## **SUMMARY OF REGULATION 19 ISSUES FOR BROADWATER ROAD WELWYN GARDEN CITY- 3.11.2010**

It is considered that a Regulation 19 notice should request the following clarification / additional information:-

05. NORTH ELEVATION

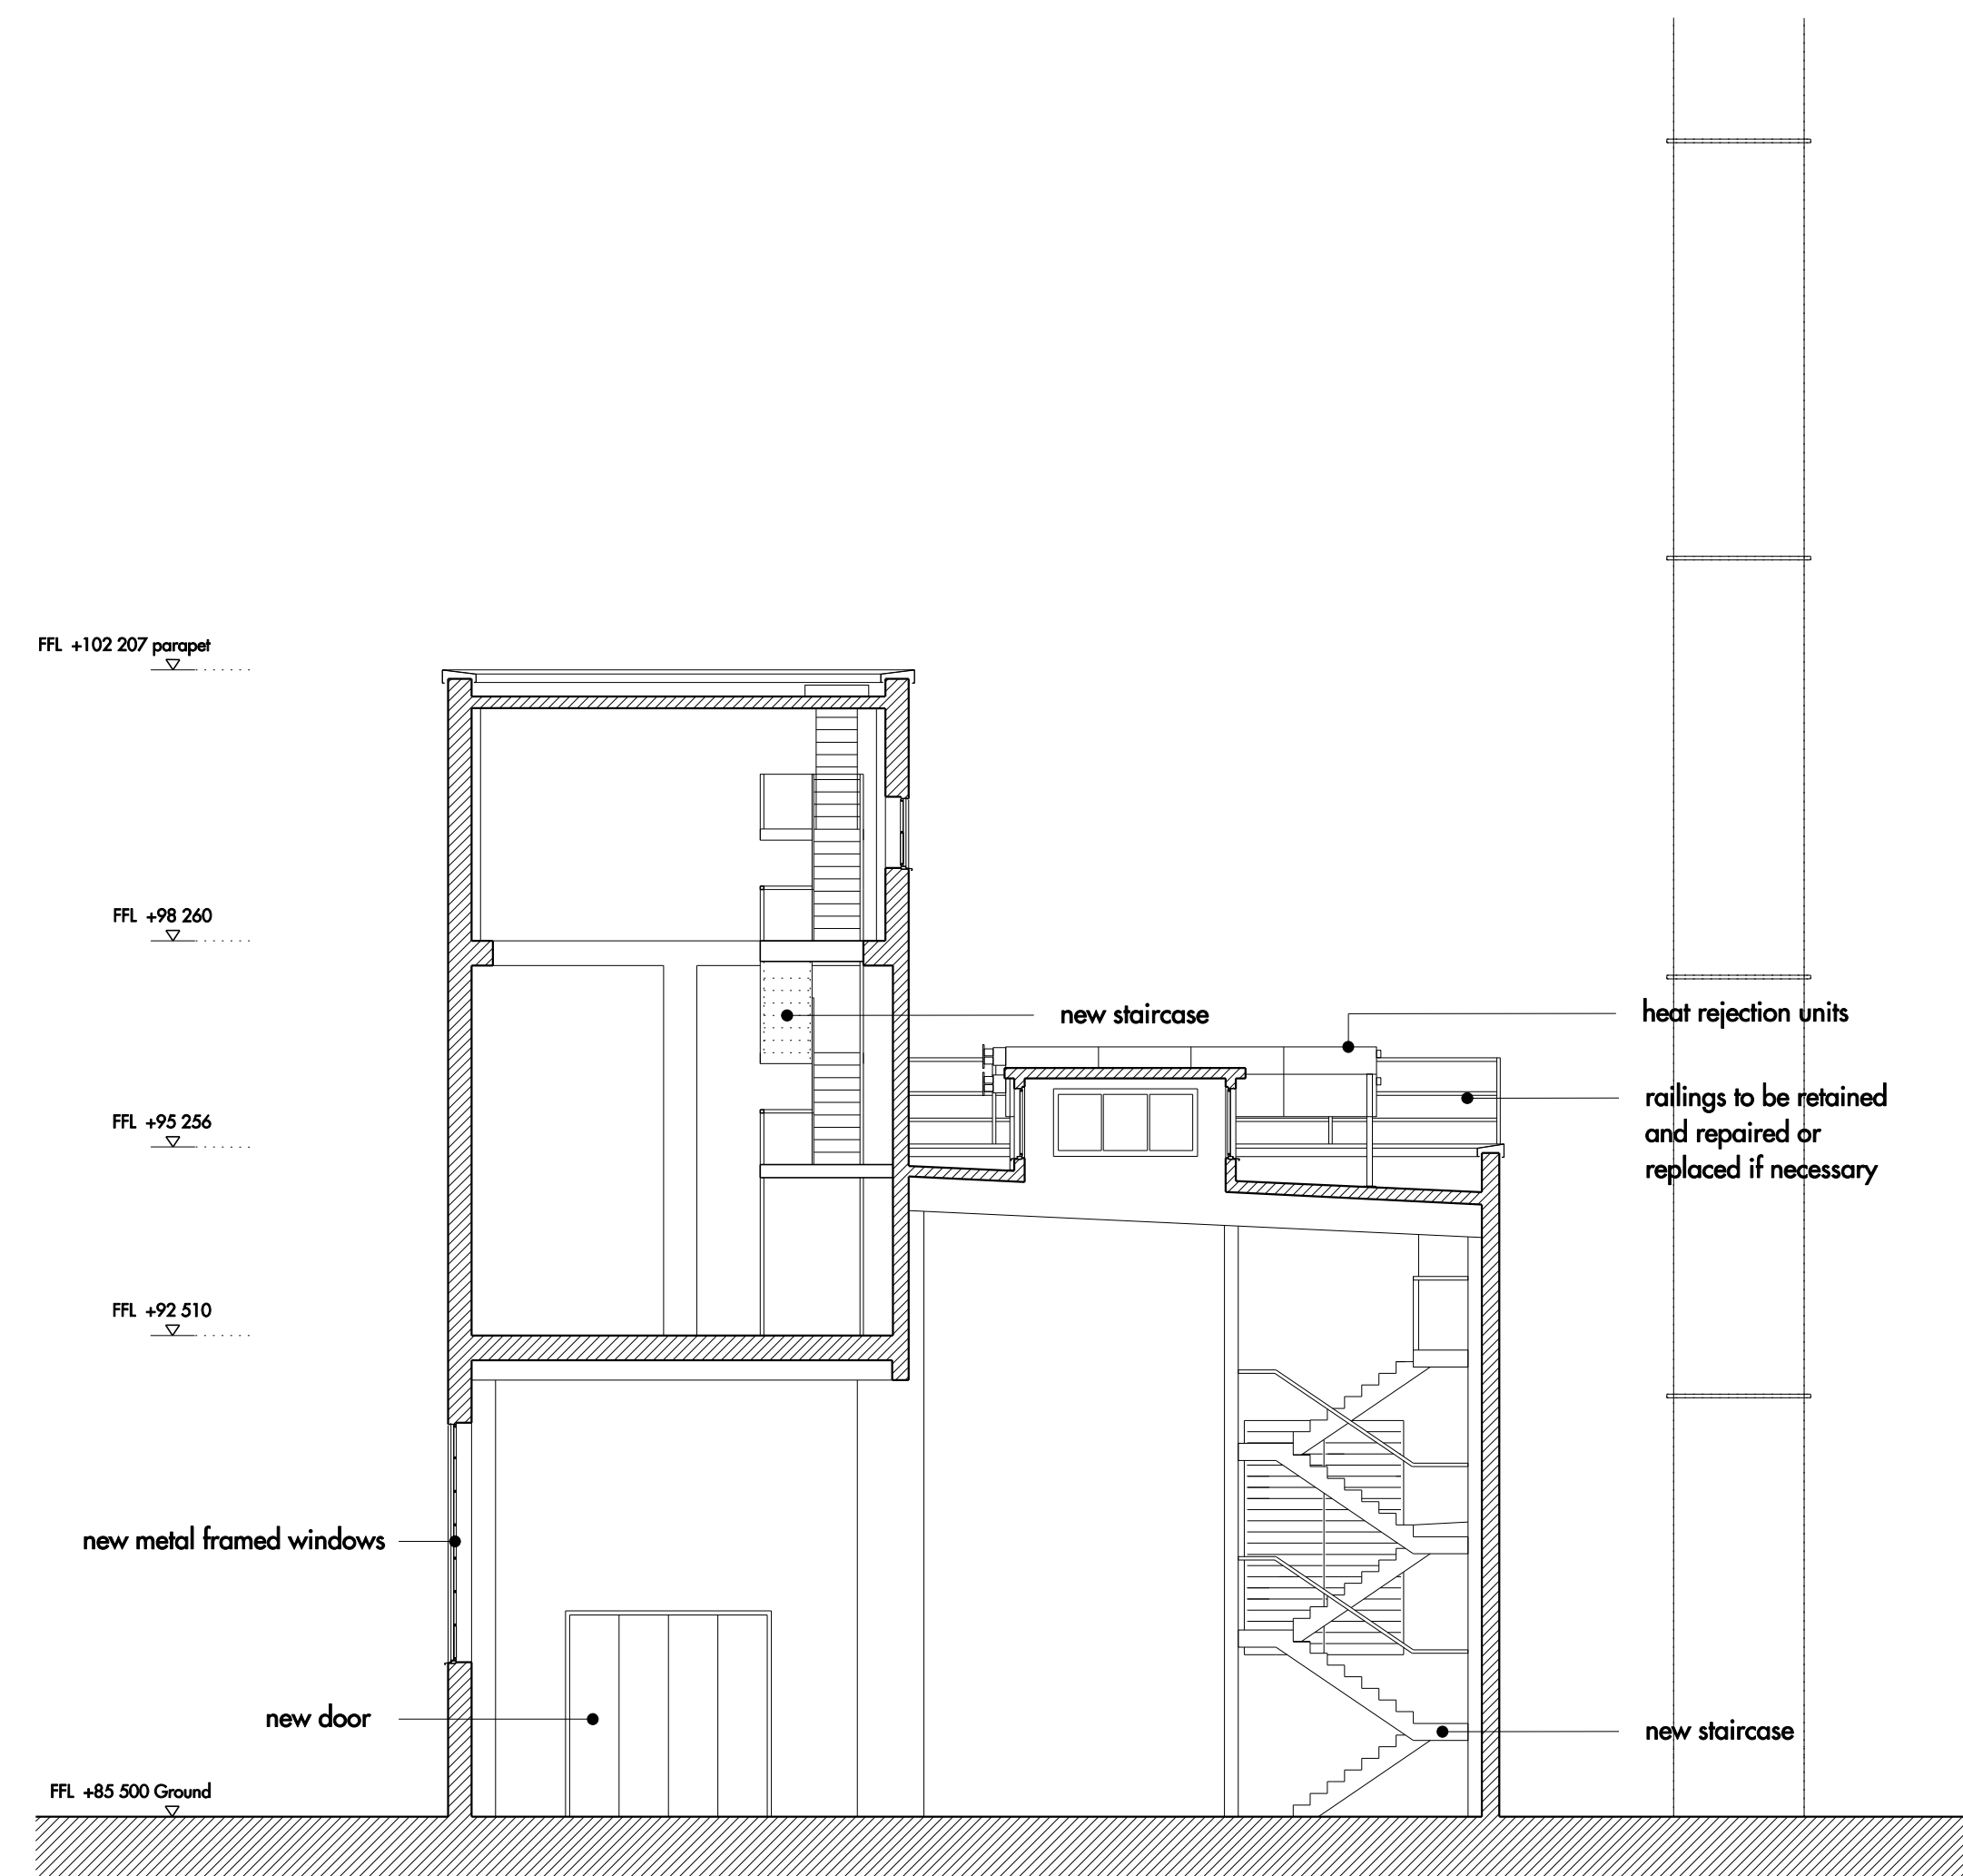
Confirmation is needed on the fuel type proposed for the CHP, and whether or not the CHP will serve the whole development. Confirmation is also needed as to whether the existing building and stack proposed to be re-used for this purpose will be adequate to house all of the plant required. Confirmation should be provided of the air quality, noise and visual impacts that will result from the CHP, as nearby residential units and other uses which may be adversely affected by the CHP lie within the area of the detailed application.
